City of Portland, Maine - Building or Use Permit Application
 389 Congress Street, 04101 Tel: (207) 874-8703, Fax: (207) 874-8716

| Permit No: 02-1271 | Issue Date: | CBL: 217 A034001 |

| Proposed Project Description: Construct New 2,816sf Single Family w/Attached 24'x25' Garage & 5'x20' Front Porch & 12'x16'Deck | Signature: | Signature: |

Addendum to specifications lot # 4 River's Edge Subdivision, Portland, Maine

KOT #4 RIVERS EDGE
 SCALE 1/4"=1'
 10/25/02
 PAGE 7 of 12
 BY PETER KRSEMANOV
 1ST FLOOR FRAMING DETAIL

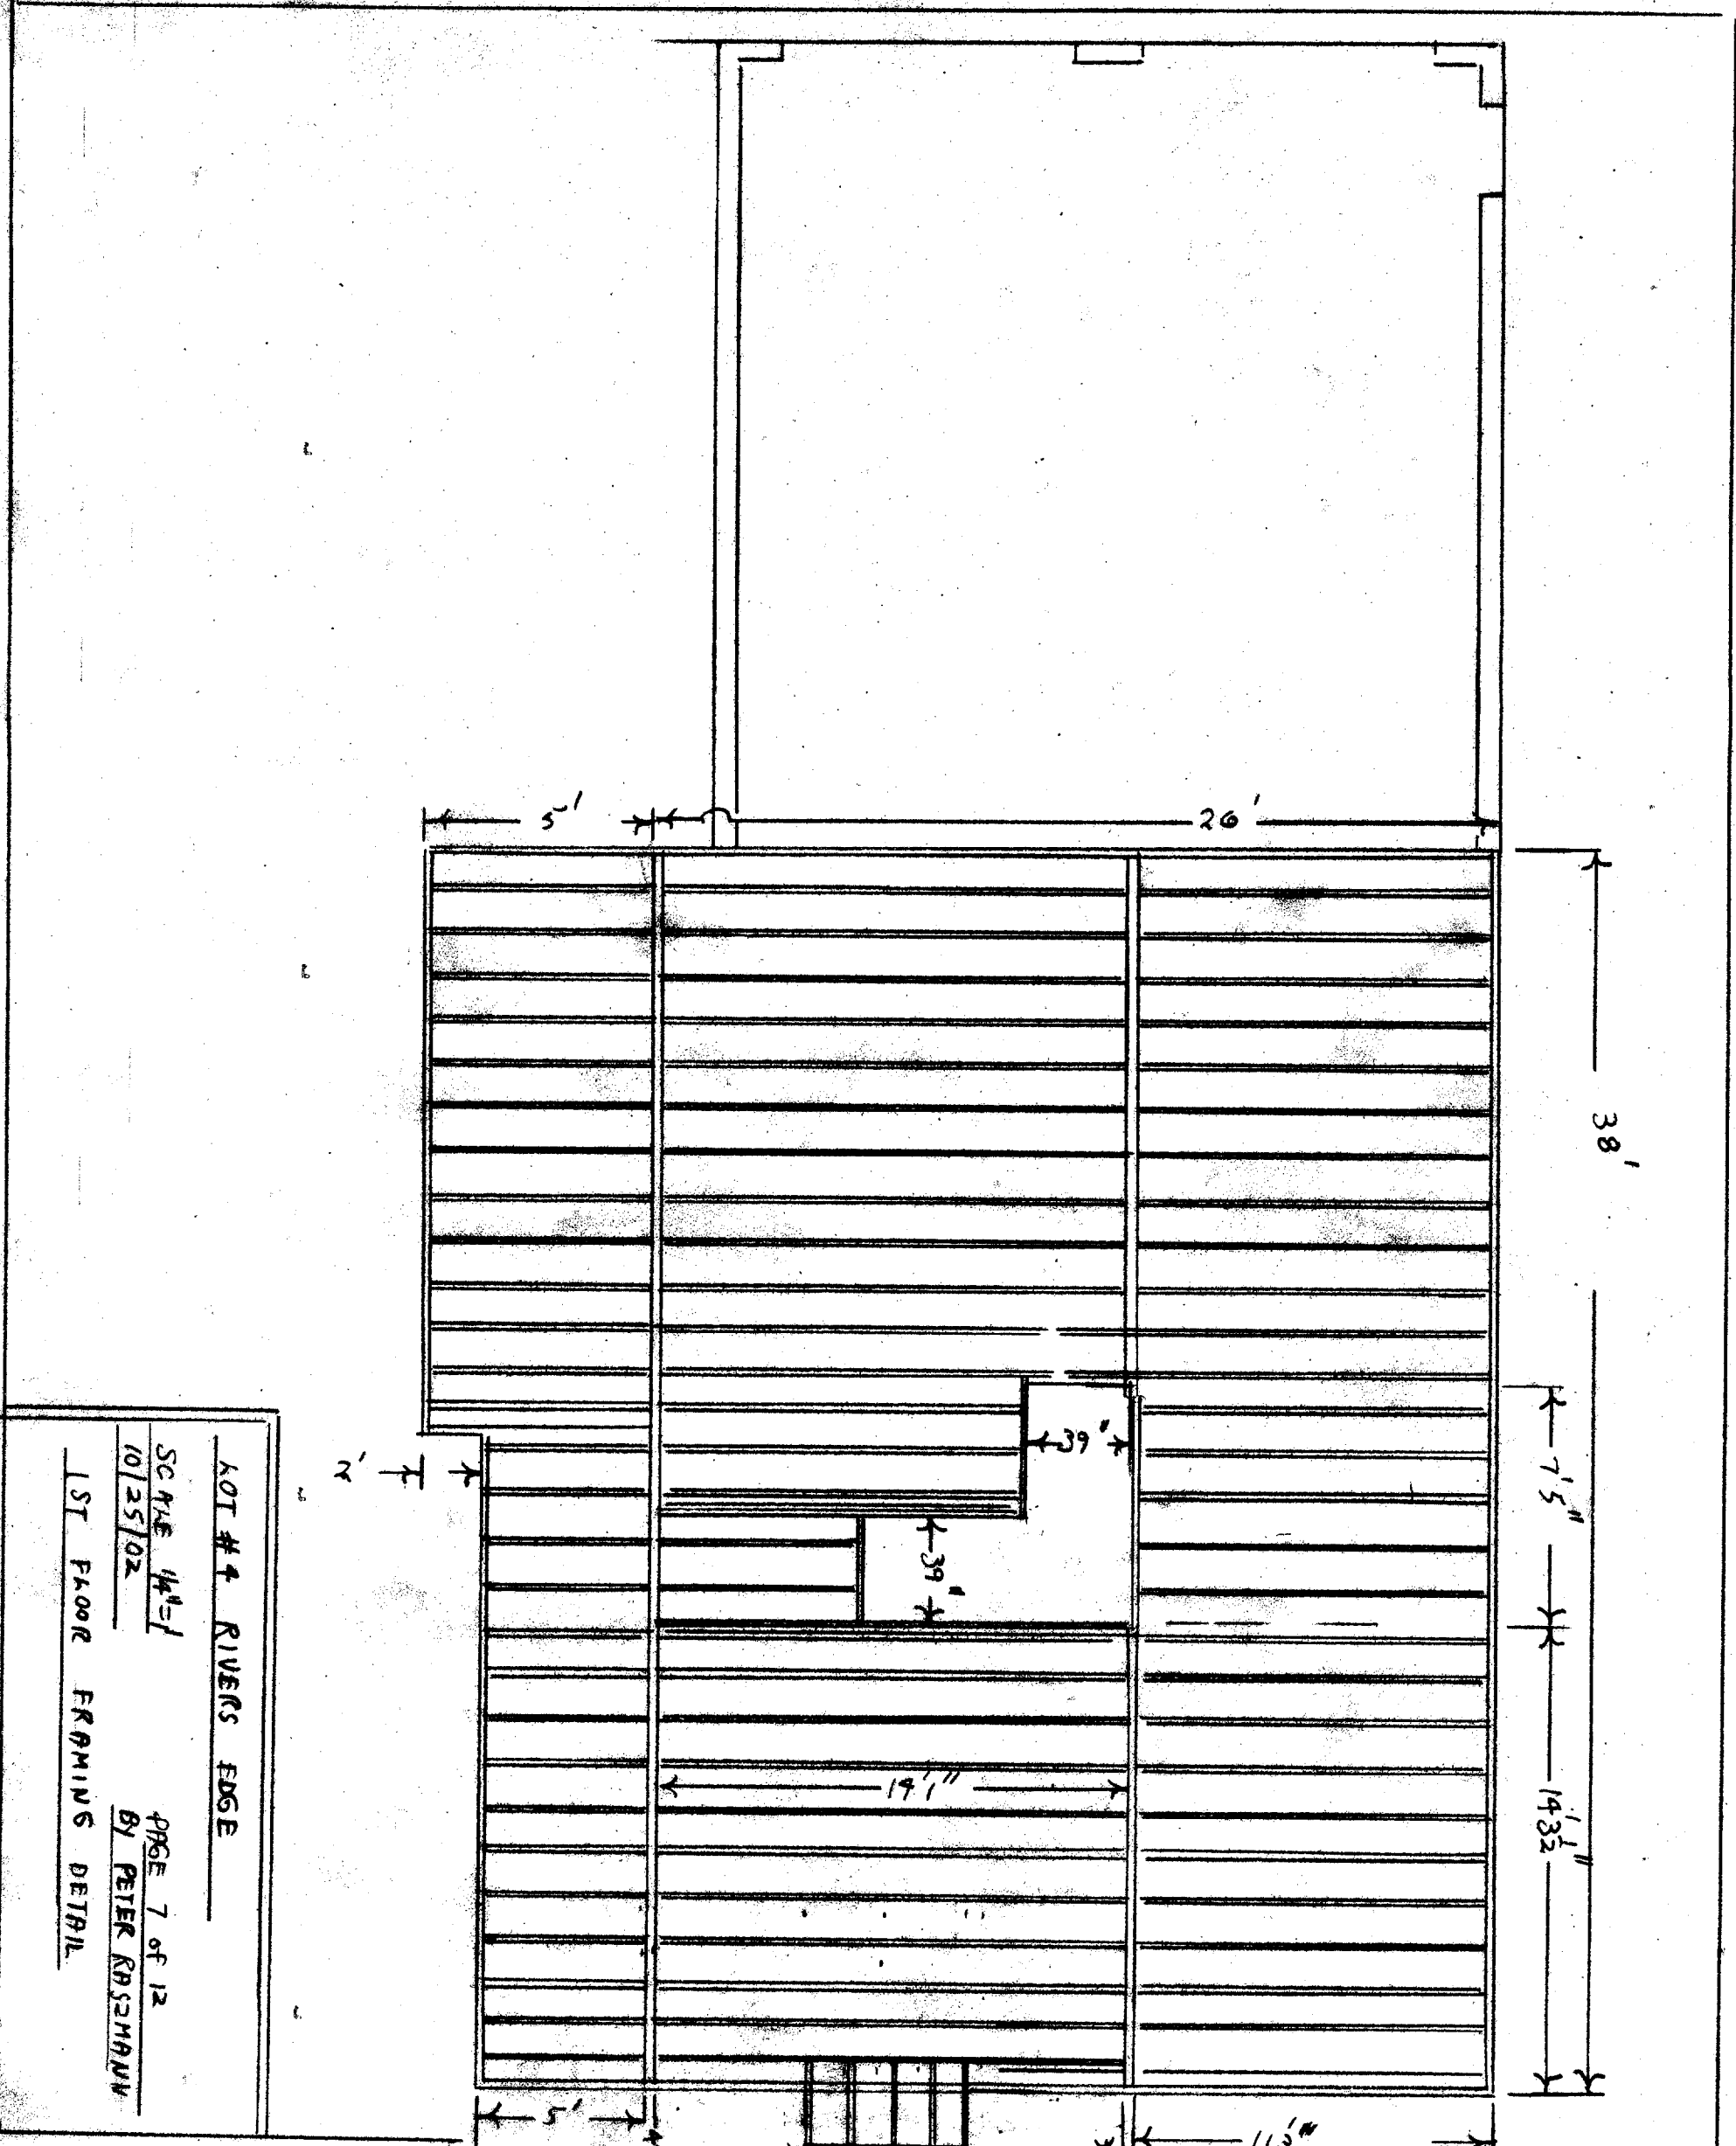
| Built-Up Wood Center Girder Dimension/Type (Table 502.3.4(2)) | UNDER DISCUSSION 2x16 GIRDER - WHAT IS IT GOING TO BE | |

1. What is the built up beam ? See attached specifications.
2. Anchor Bolts / See specifications
3. Drainage pipe will be 4" perf pipe covered with filter fabric .Damproofing/ See Specifications .
